Your Ref: EN020034  
Our Ref: Z004350

22nd September 2023

Between Creyke Beck Substation Cottingham East Yorkshire to High Marham Substation Nottinghamshire - Application by National Grid Electricity Transmission for an Order granting Development Consent for North Humber to High Marham Project

Figure 11-3. Source Protection Zones

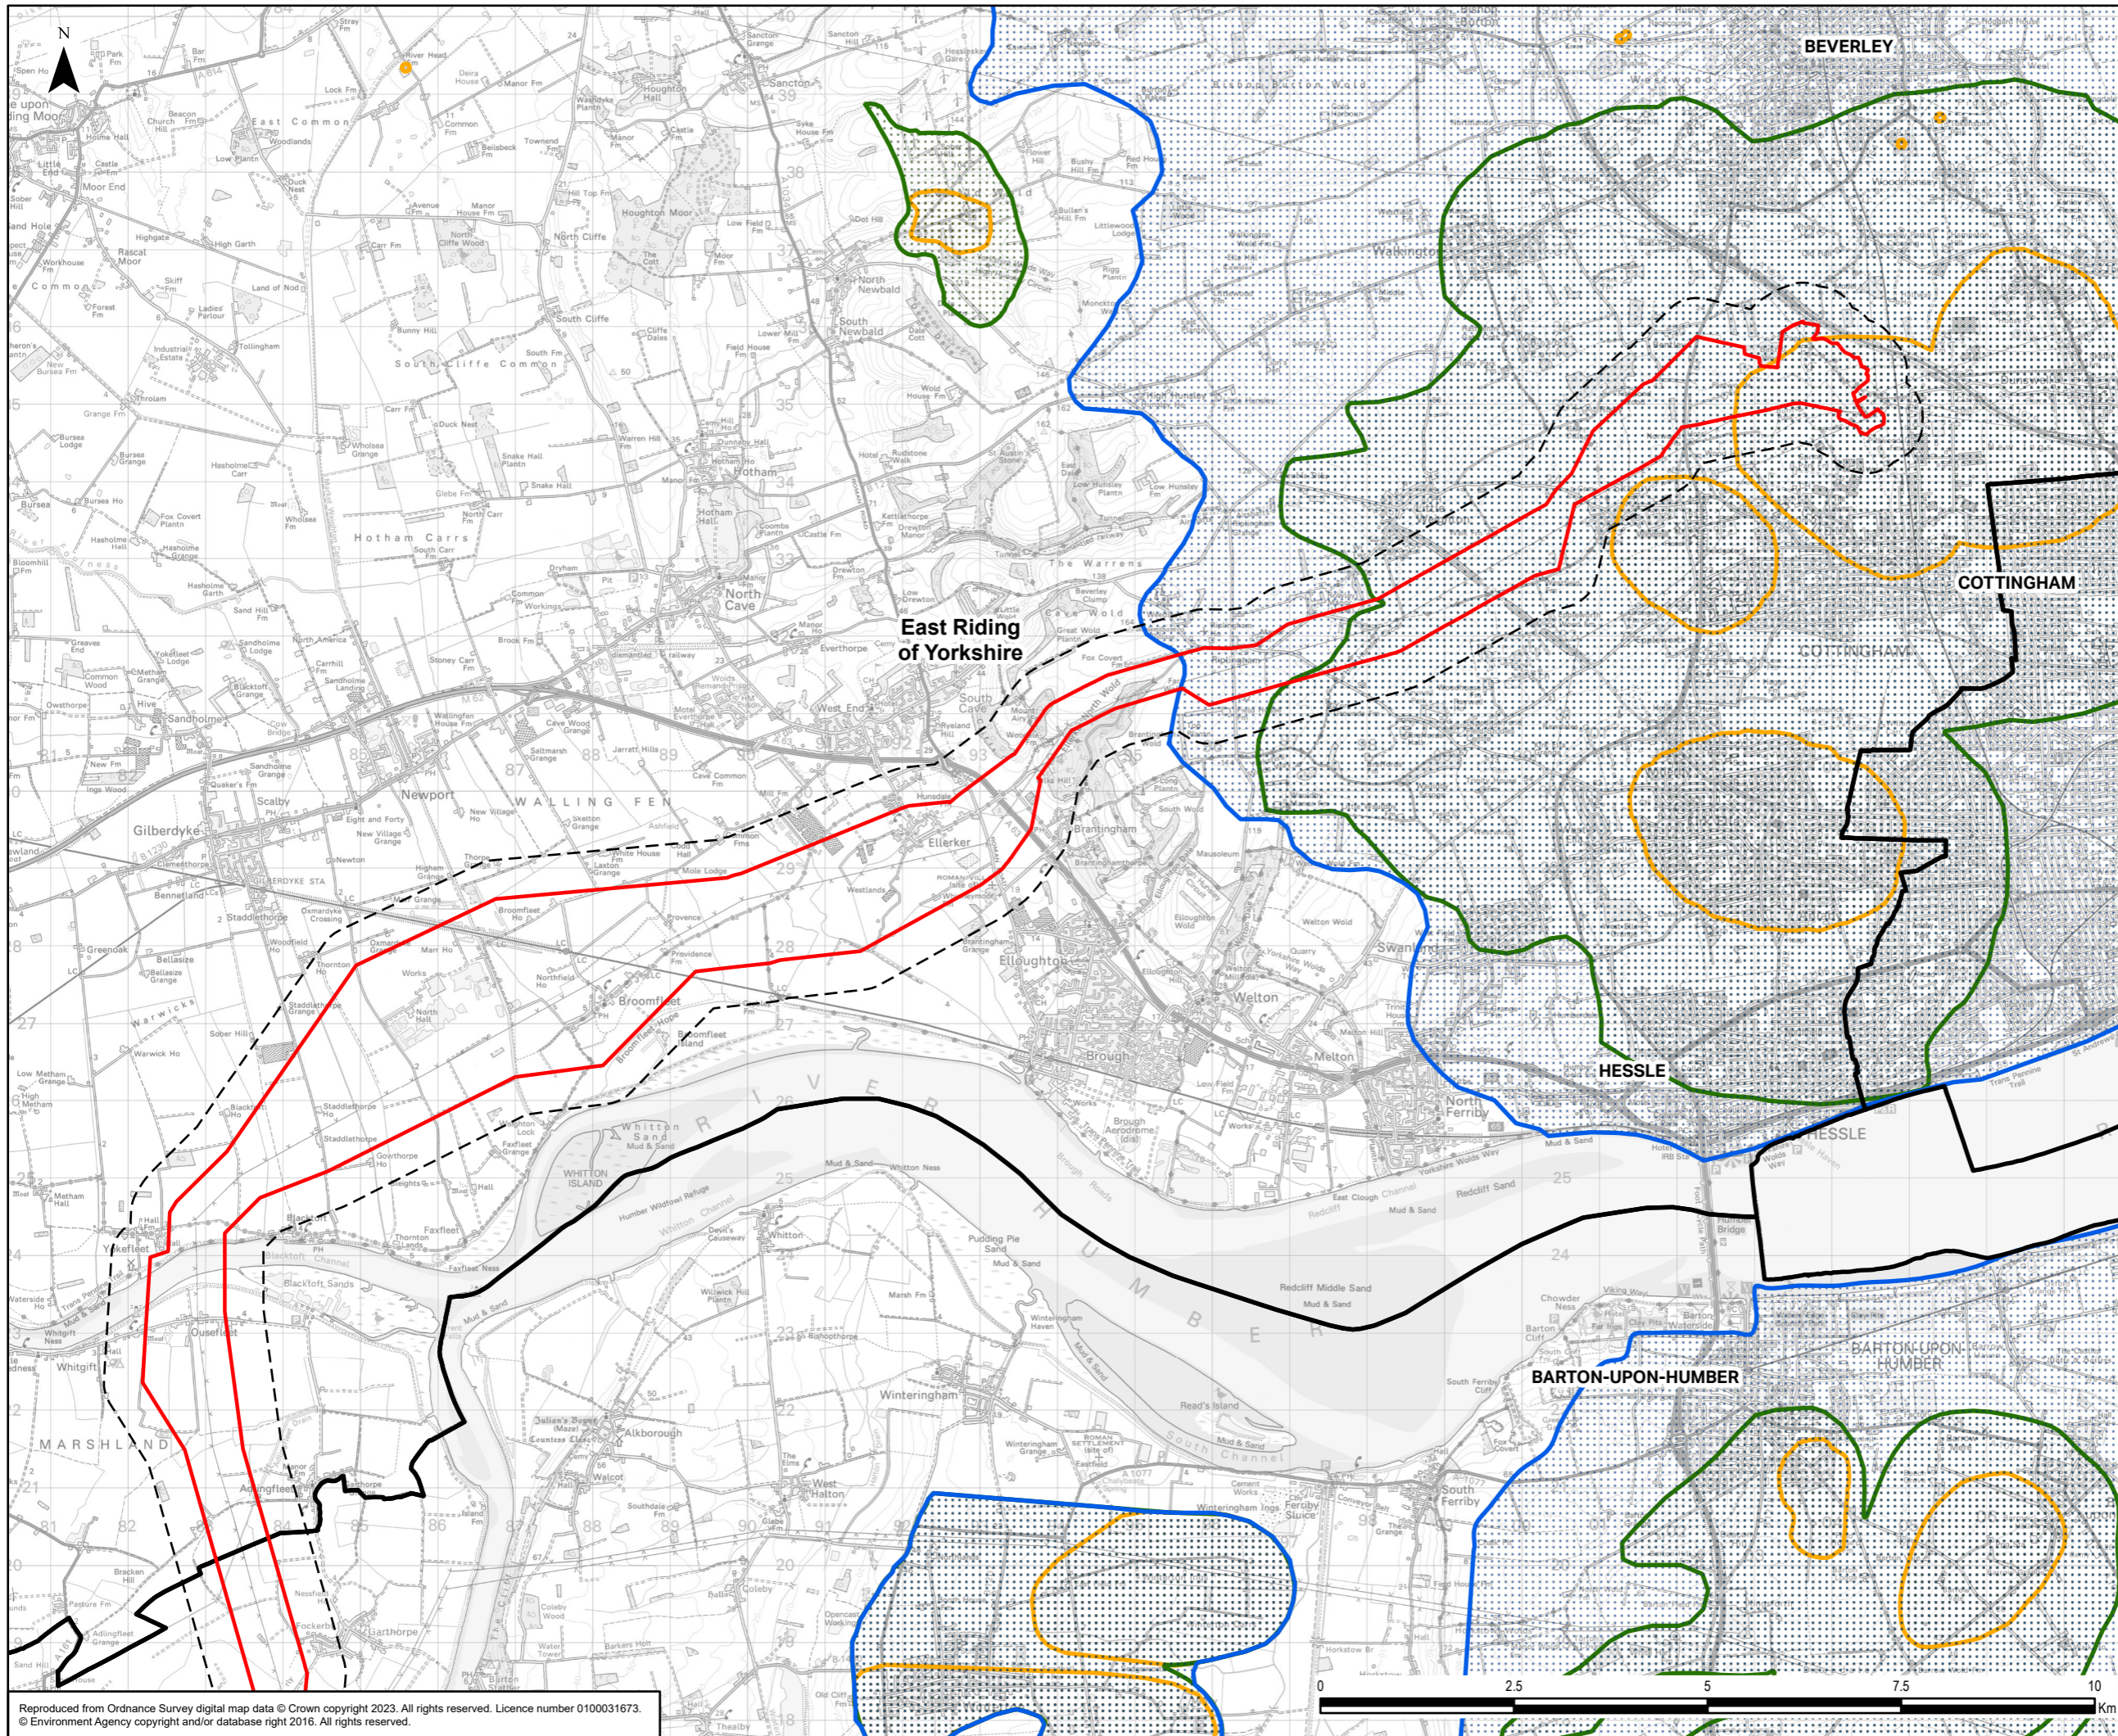
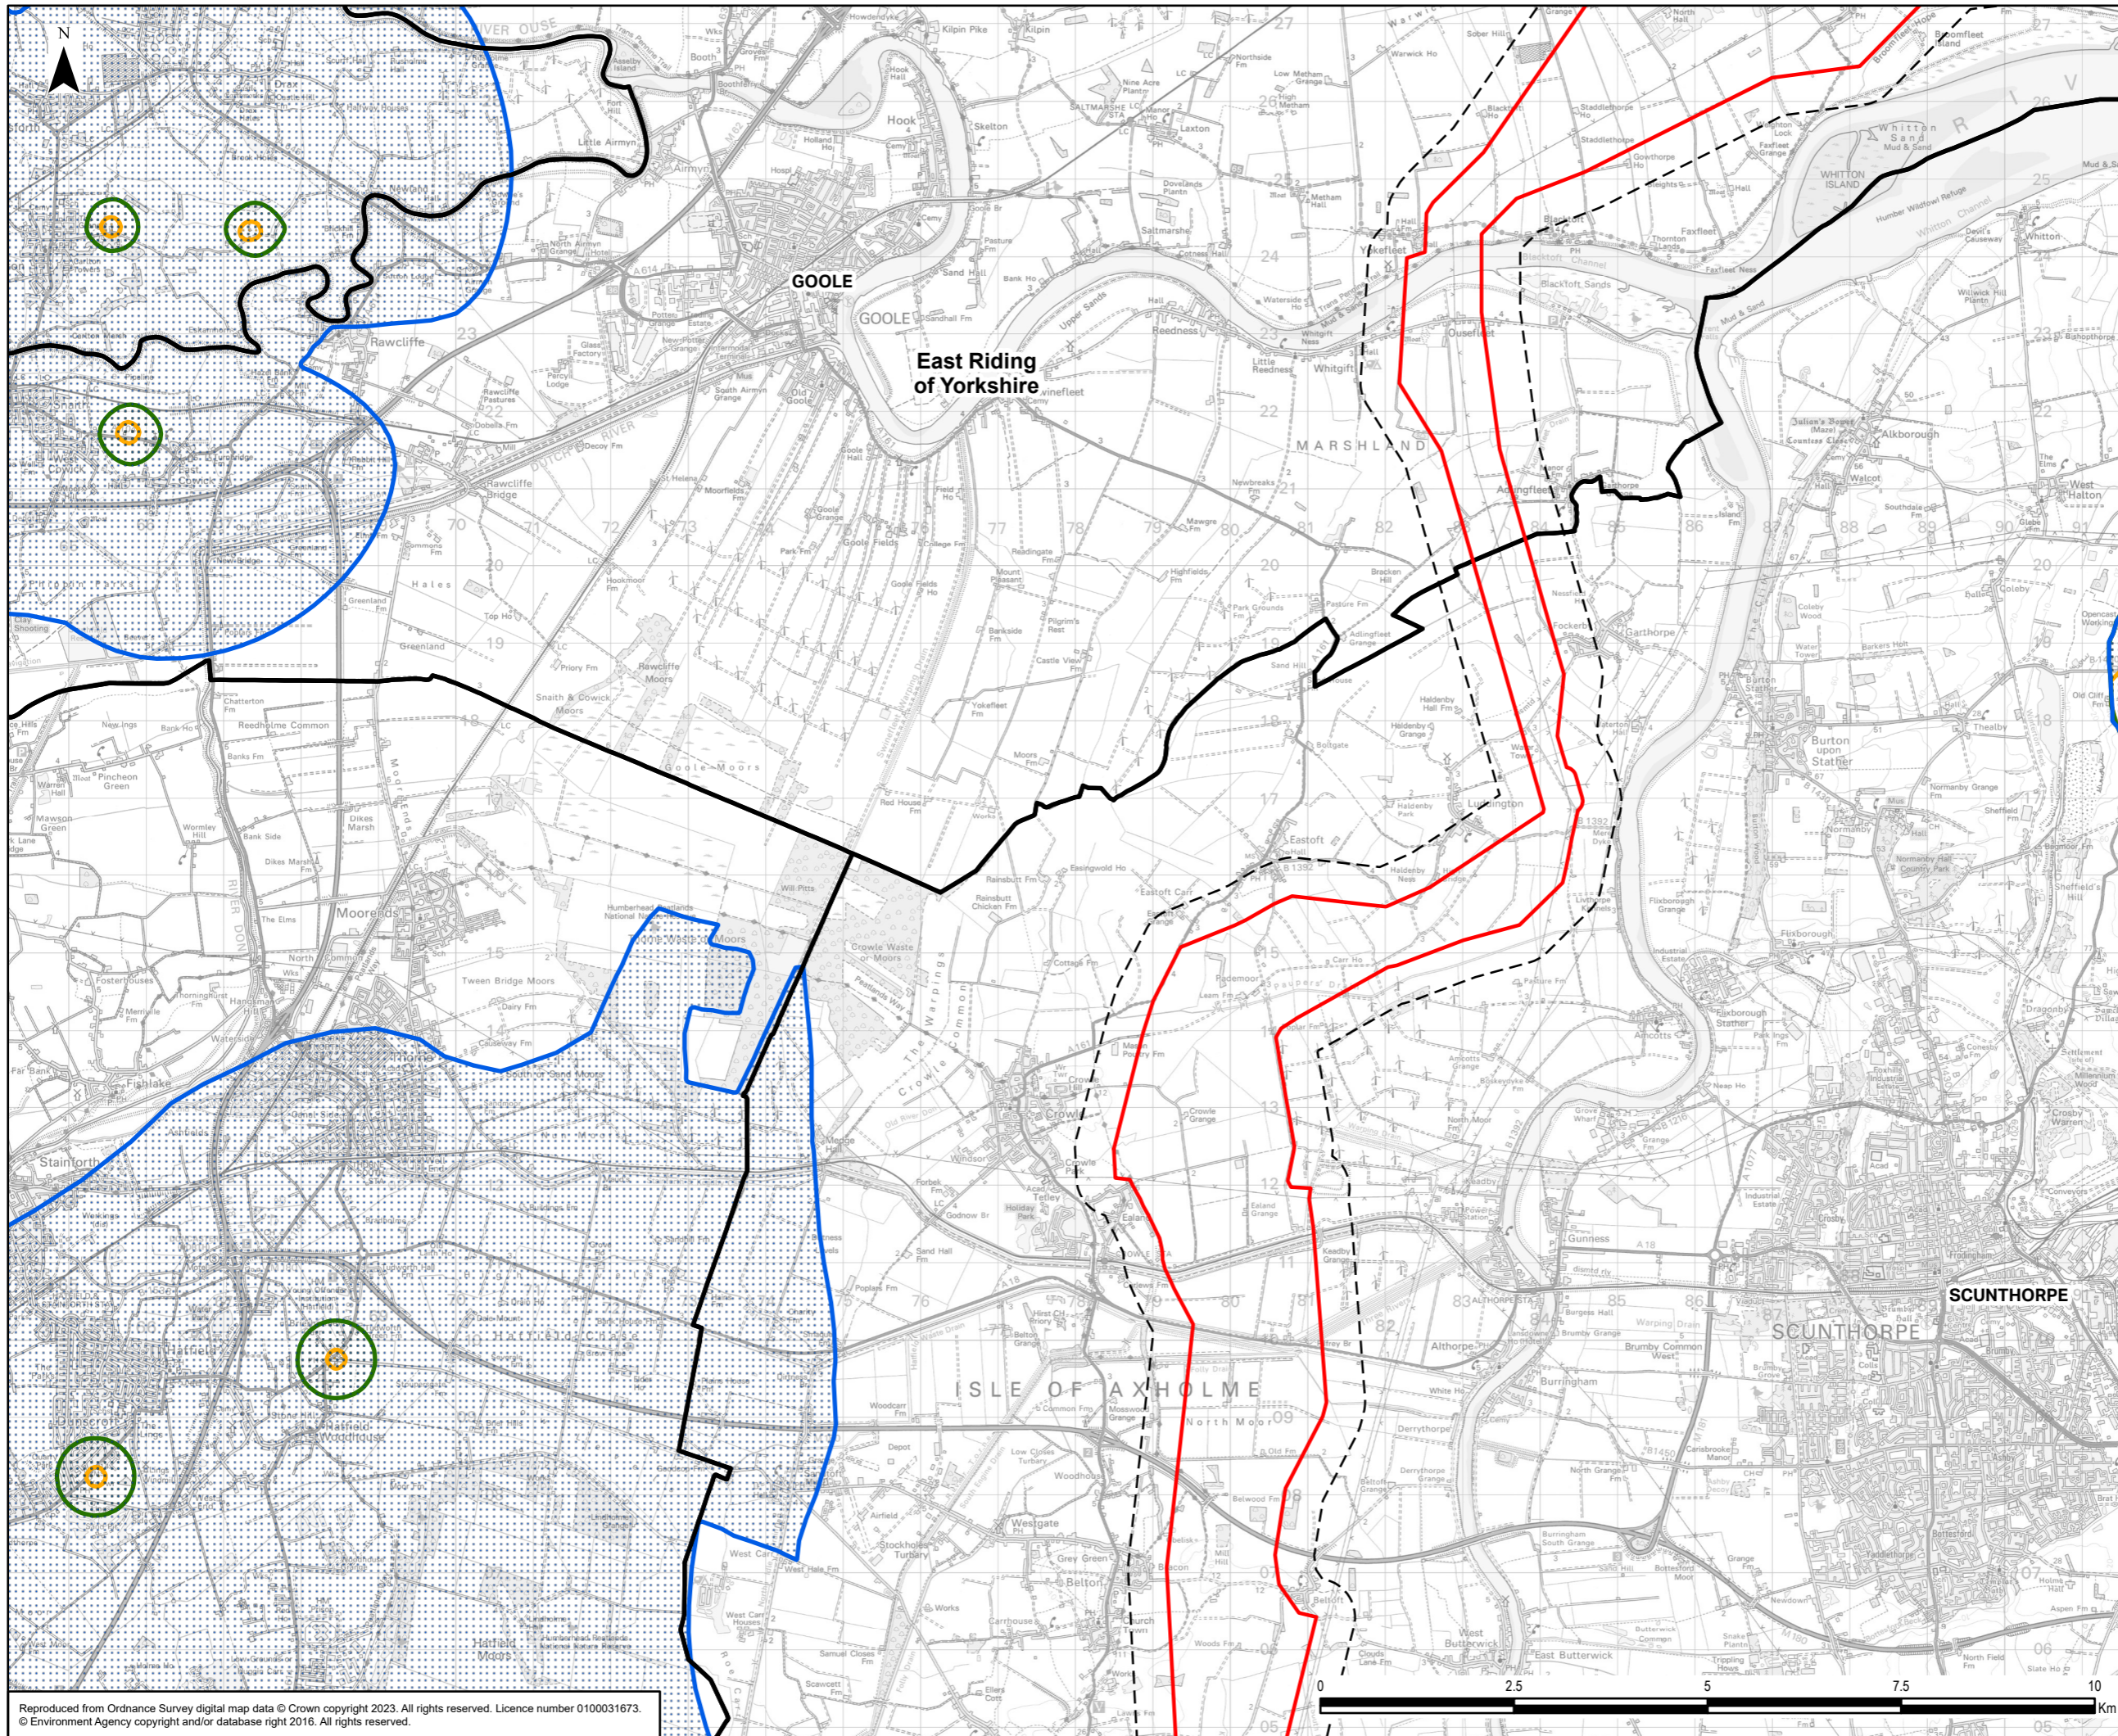
A small part of the identified scoping boundary passes through the separate SPZ1 areas of both Keldgate and Dunswell Source Protection Zones and the associated SPZ2 and SPZ3 zones for these protection areas. The EIA Scoping report Volume 1, ref: CGNC-NG-CNS-REP-0002 advises that majority of the geology and hydrogeology topic will be scoped out advising significant effects are unlikely with the proposed mitigation and control measures.

However, some elements of the geology and hydrogeology topic will be scoped in, including trenchless crossings. Trenchless crossing are not currently proposed although any significant effects on the SPZ zones as a result of intrusive ground works will be considered. The ES will also be supported by a CEMP detailing the use and storage of chemical and fuels. The scope of this chapter is acceptable to YW.
